Addendum No. 2

RE: Contract ID C203394

Durham County (U-0071)

East End Connector From North Of NC-98 To NC-147

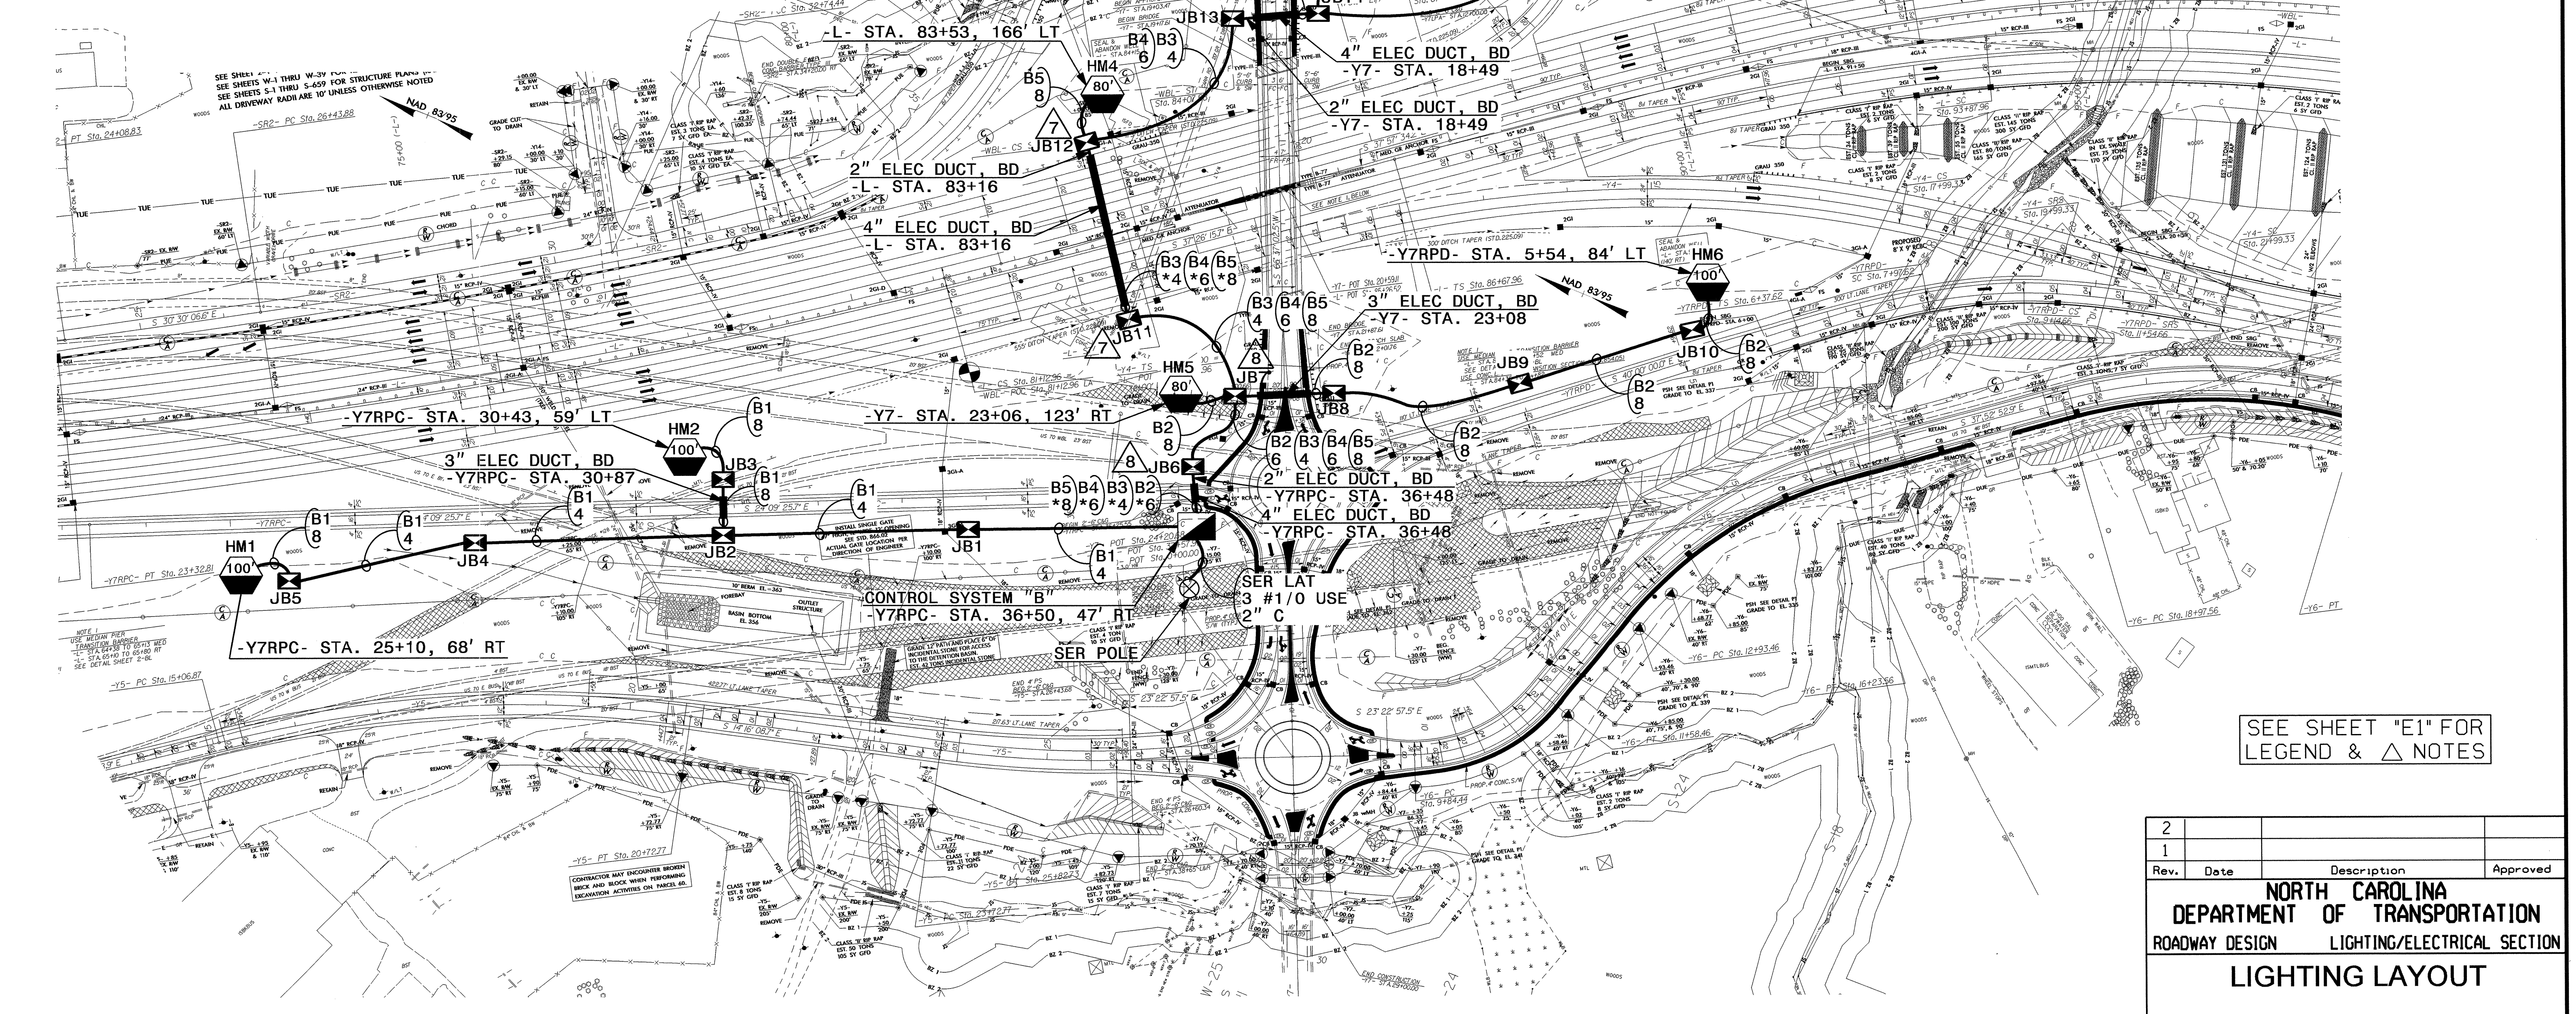
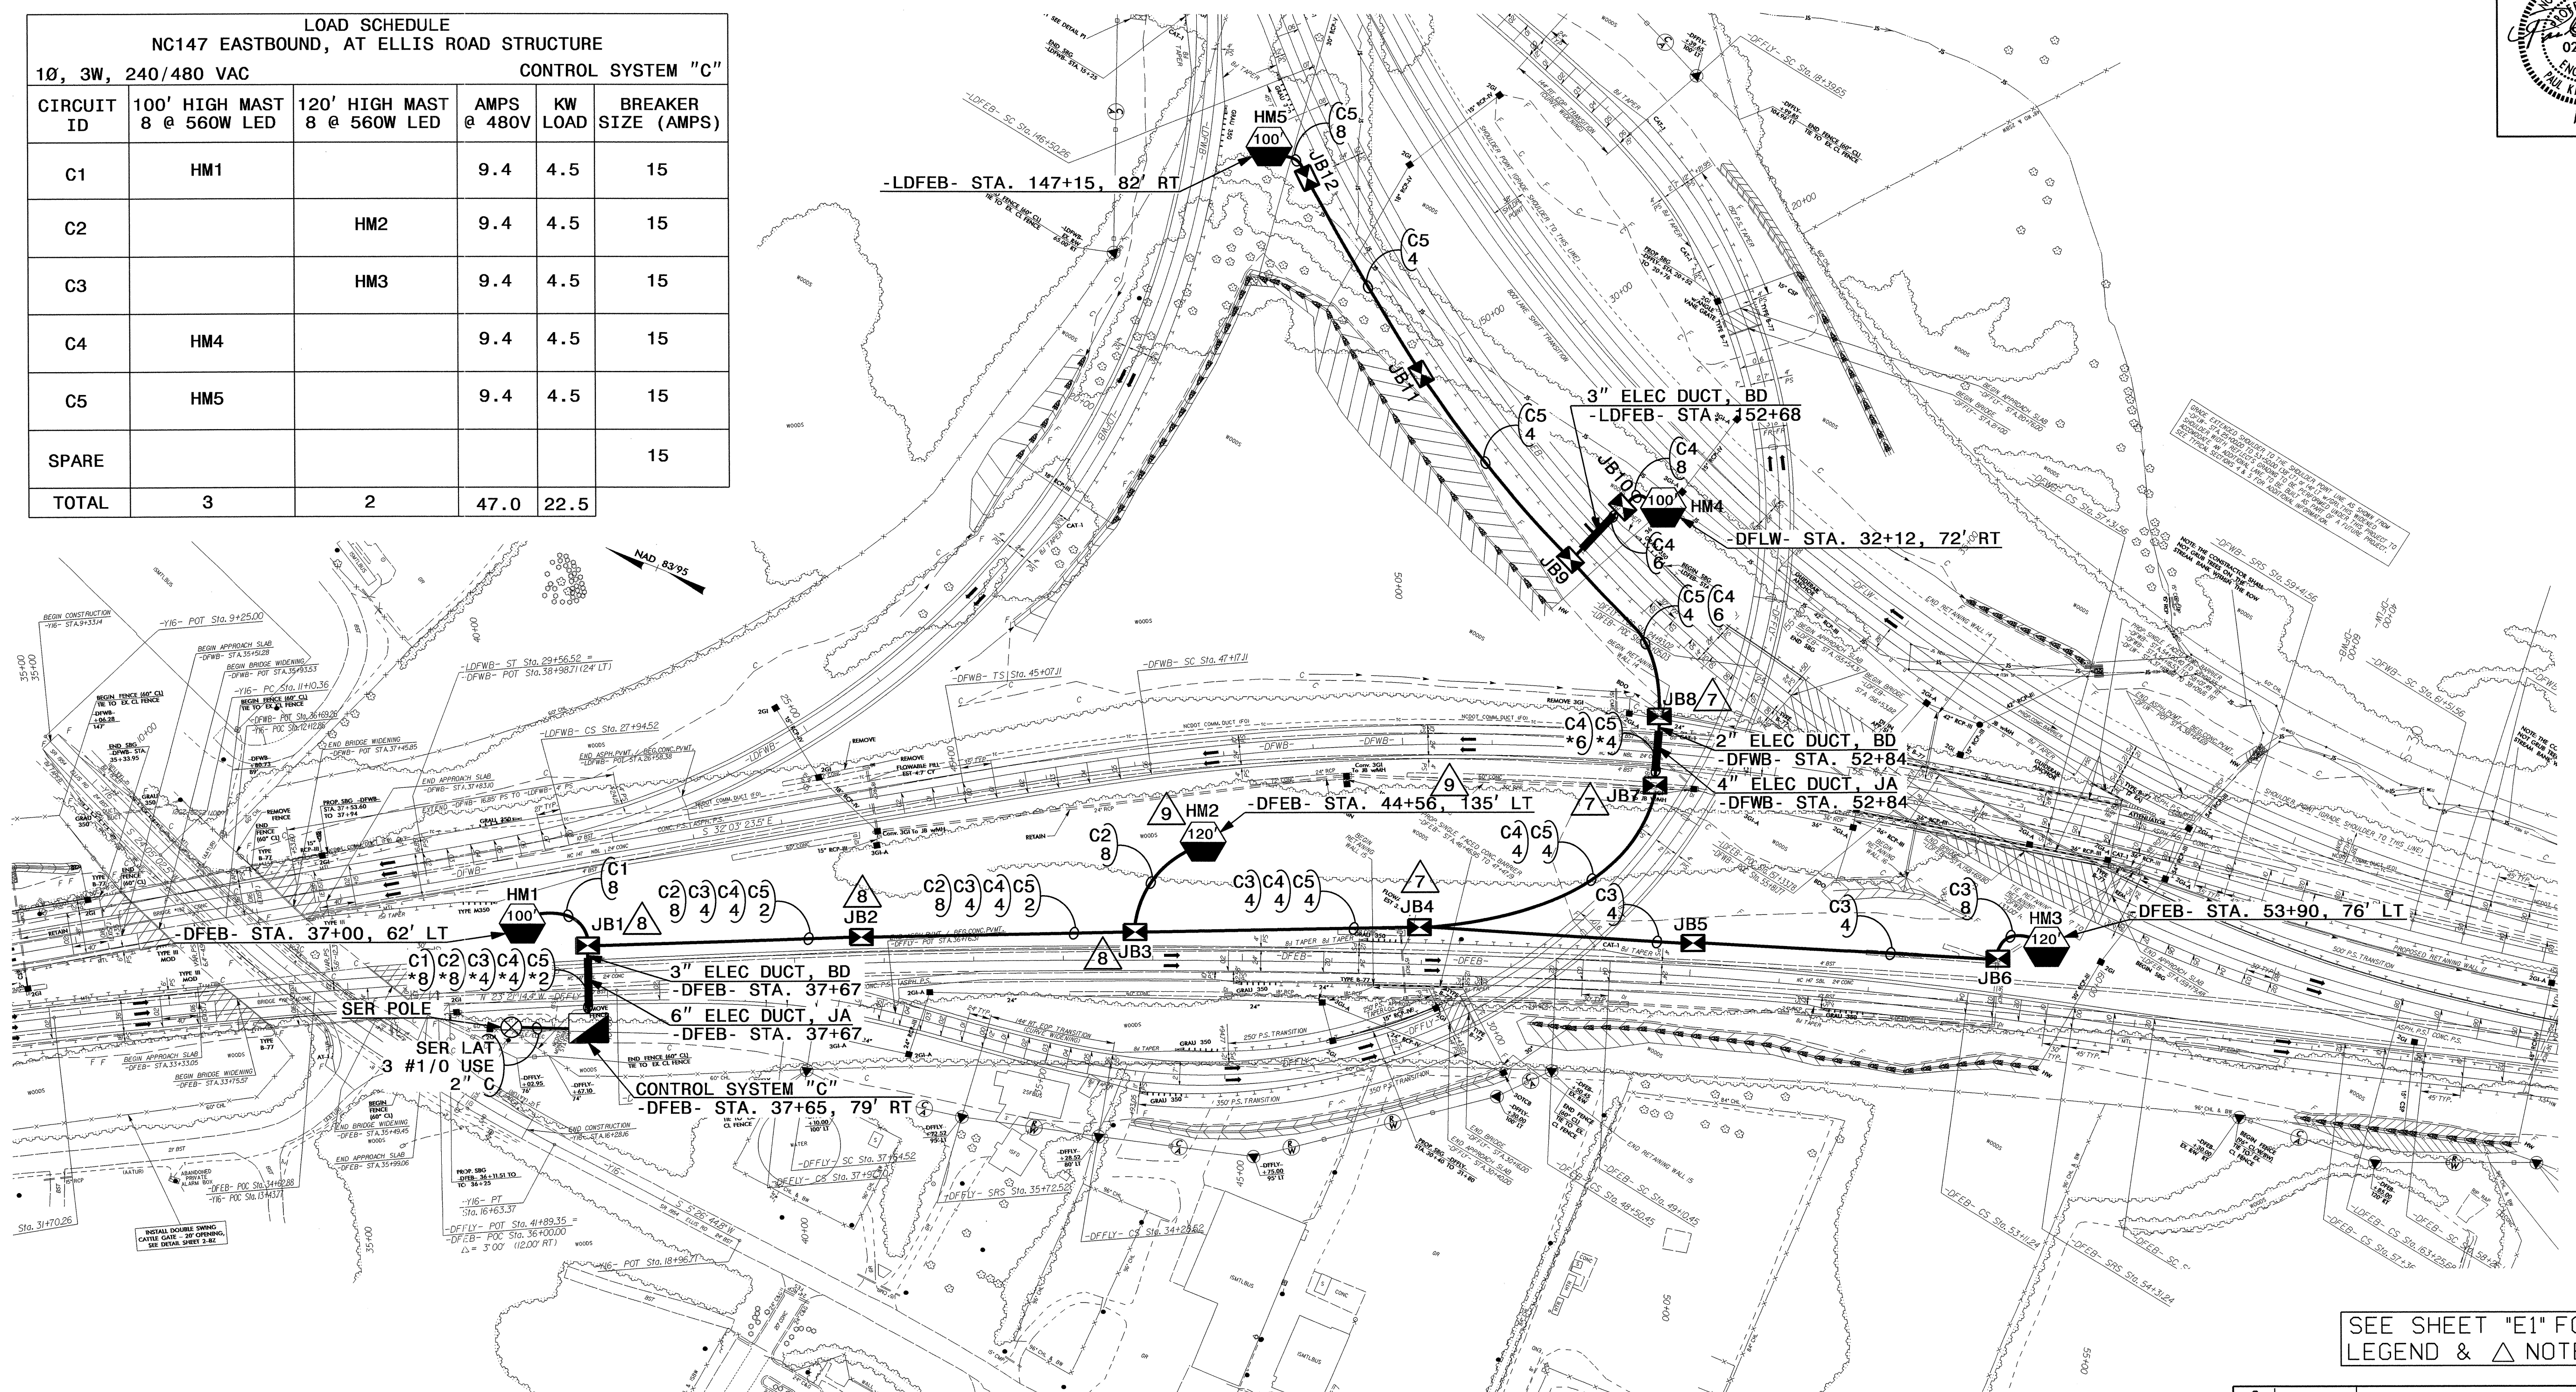
Sheet No.	Revisions
E1 thru E5	Revised to change from HPS luminaires to LED luminaires
